Re: **Marysville Corporate Center**
Binding Site Plan, PA22-004
Project Number 2200444.00

In response to your plan review checklist dated April 27, 2022, we have addressed the items below, with our responses following your comments.

PRELIMINARY MARYSVILLE CORPORATE CENTER BINDING SITE PLAN FILE NO. _____

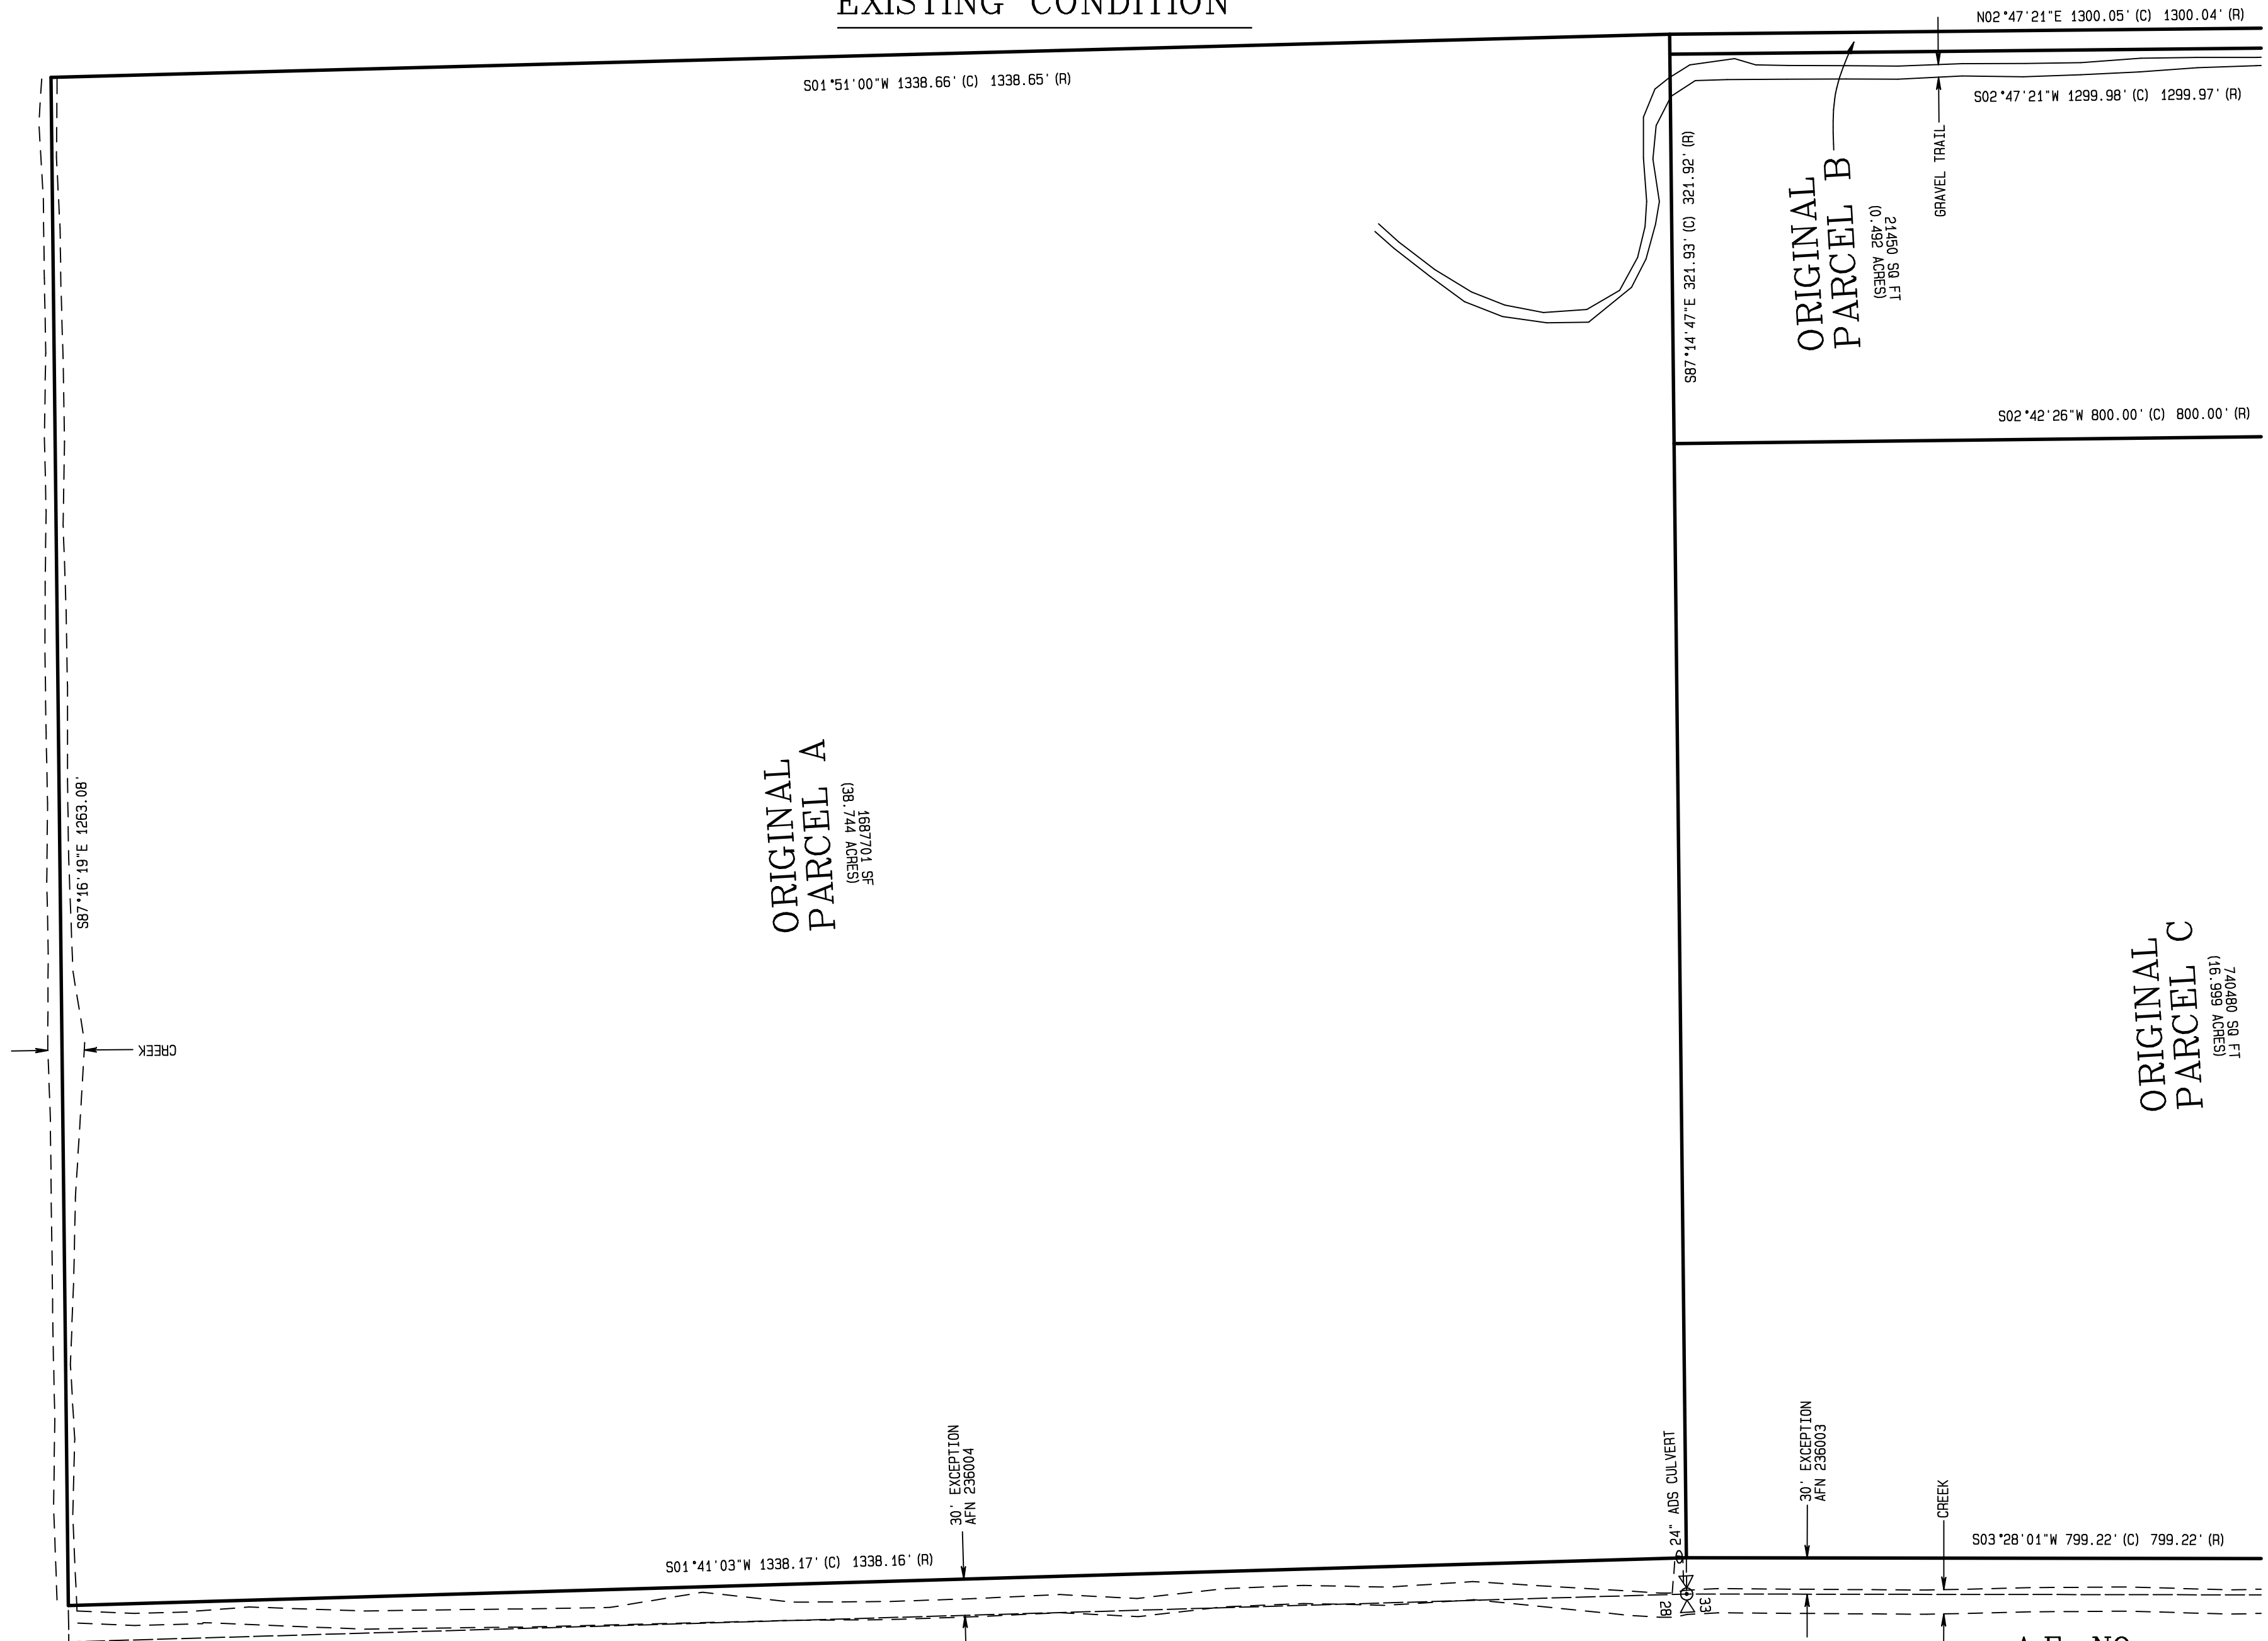
- a. *156th Street NE will require a 90 foot dedication.*

Response: A 90 foot right of way dedication is shown on the preliminary BSP.

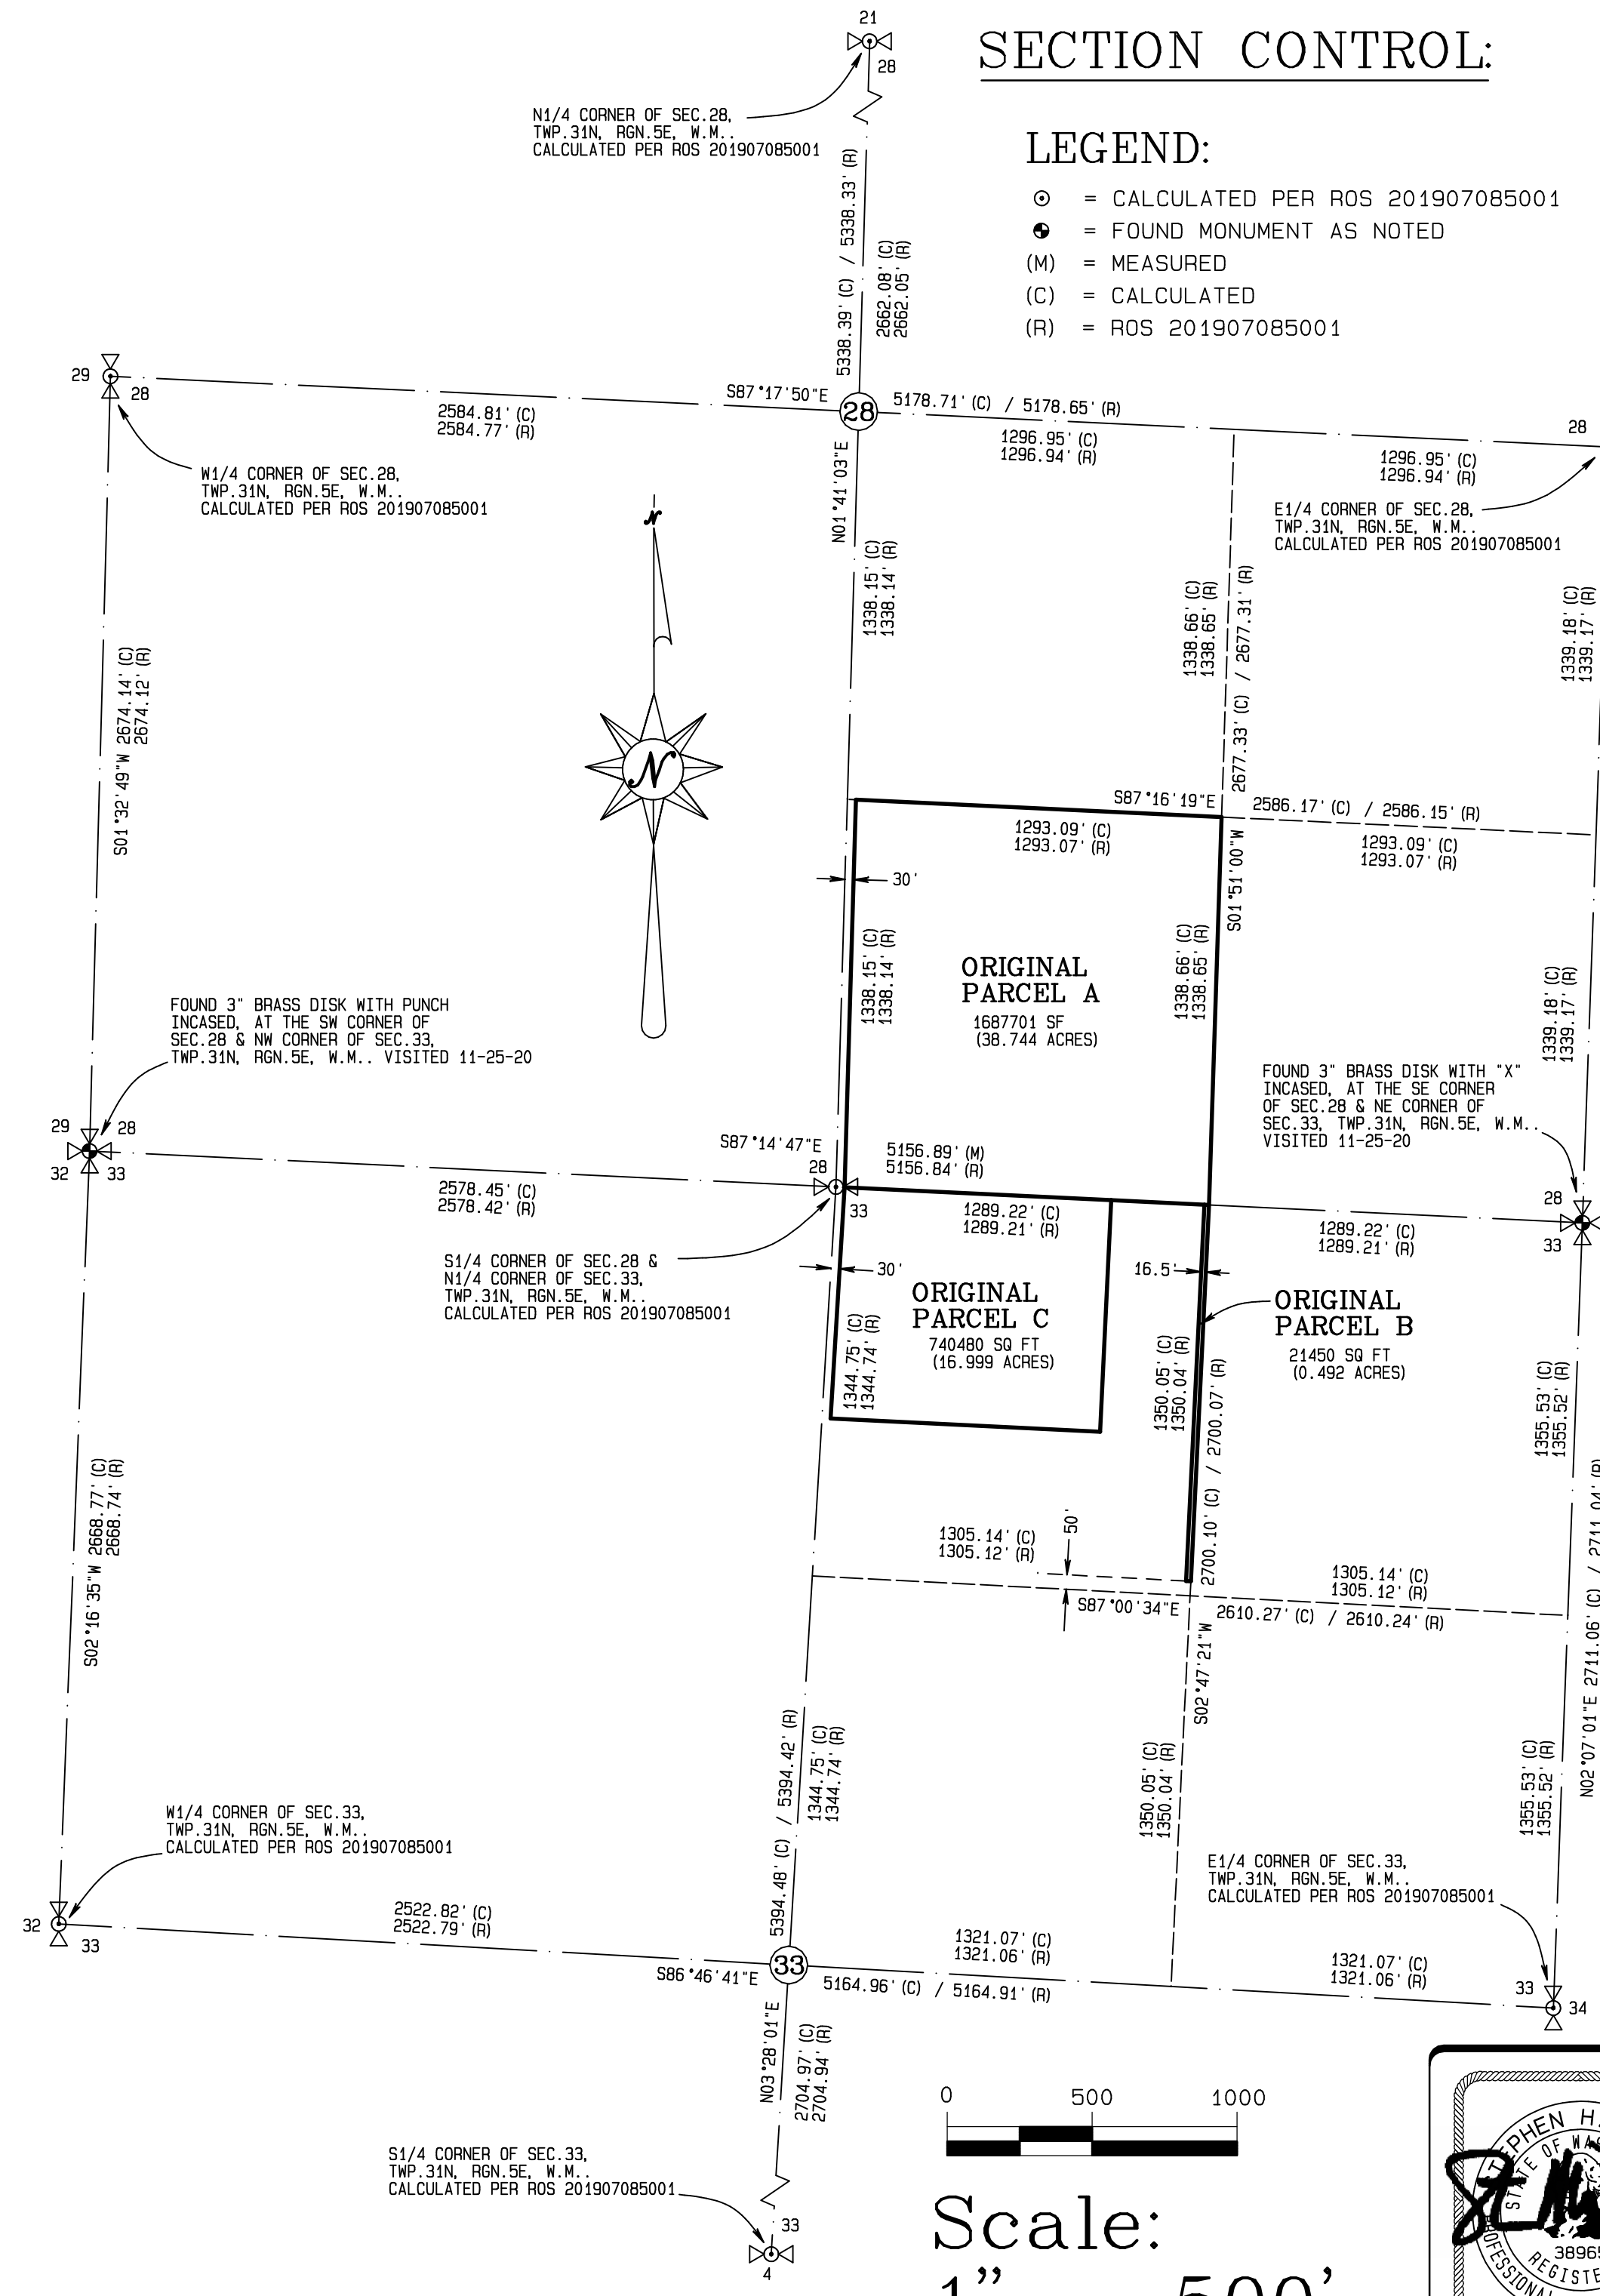
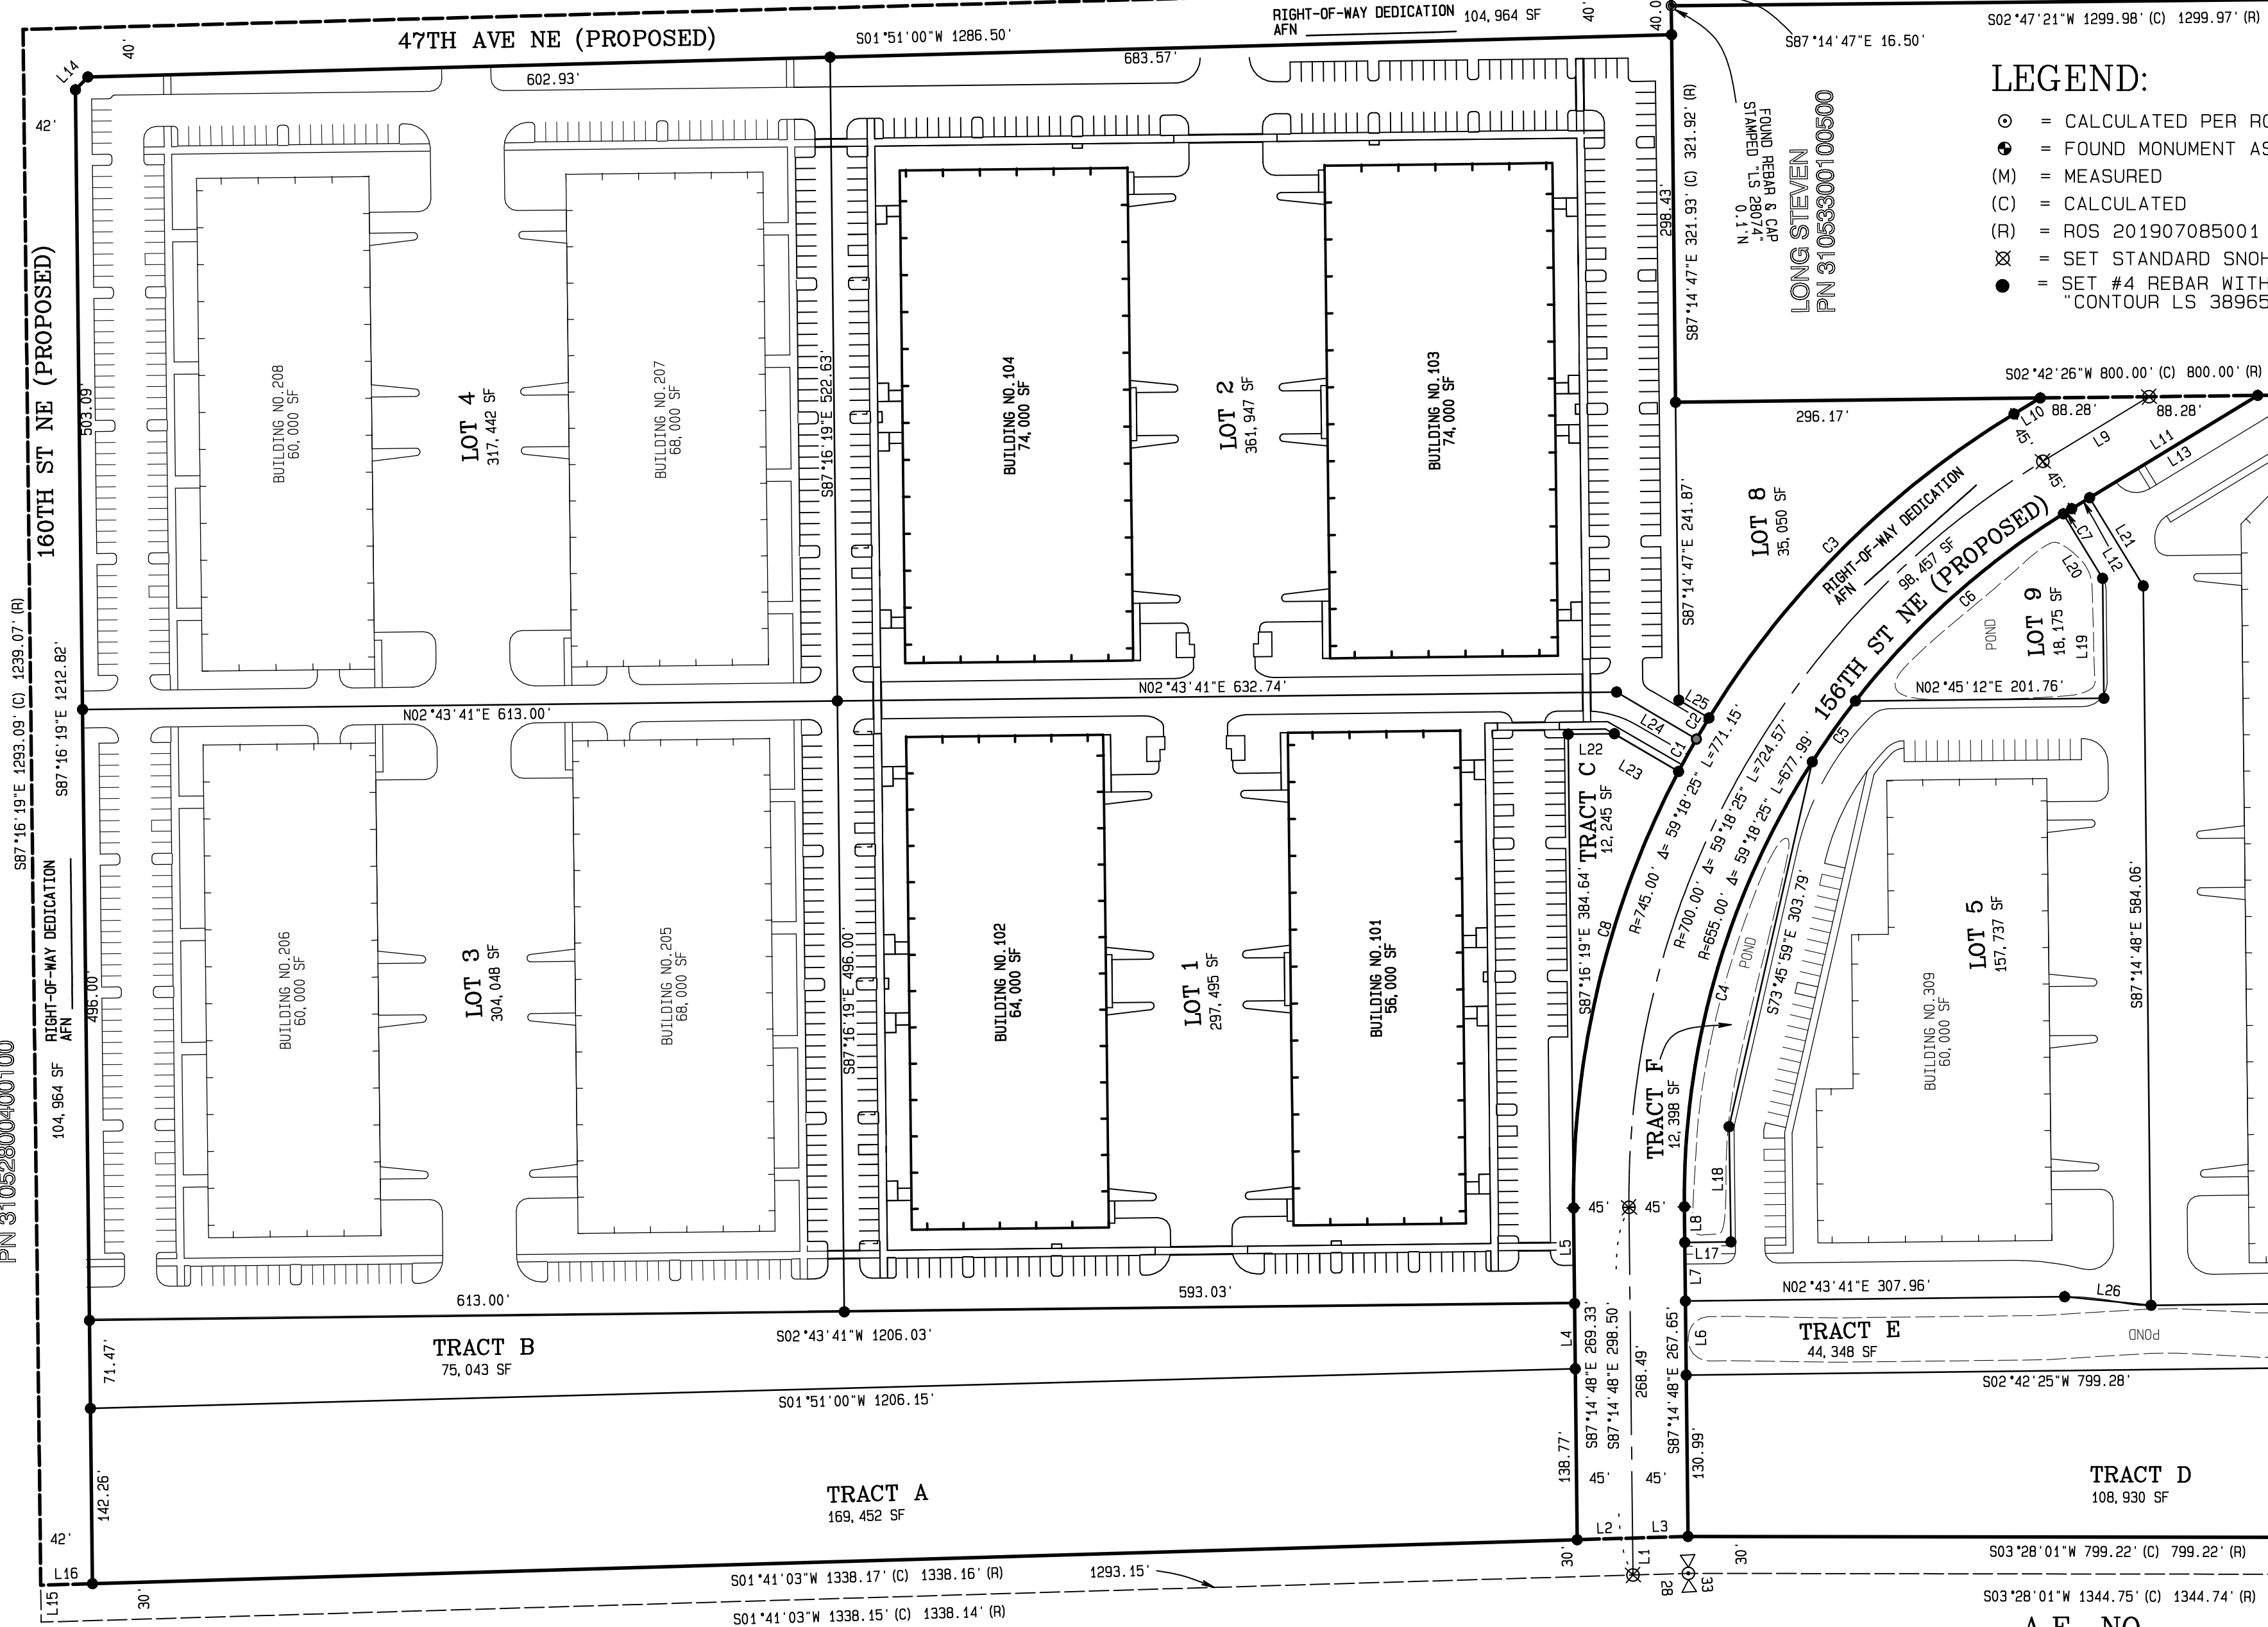
- c. *47th Ave NE is at full build out is to have 2 travel lanes, with a turn lane, curb and gutter with a planter and sidewalks. See the diagram below.*

A half street design will be allowed. The proposed alignment for future 47th Ave has changed, I'll include a diagram of the alignment in my response.

- c. *47th Ave NE will need to have 35 feet of dedication. If the multi-use path is on the west side of the road a 40 foot dedication will be required.*

Response: Right of way dedication is shown on the preliminary BSP, no improvements of 47th Avenue are shown at this time.

Response: A 40 foot right of way dedication is shown on 47th Avenue NE.
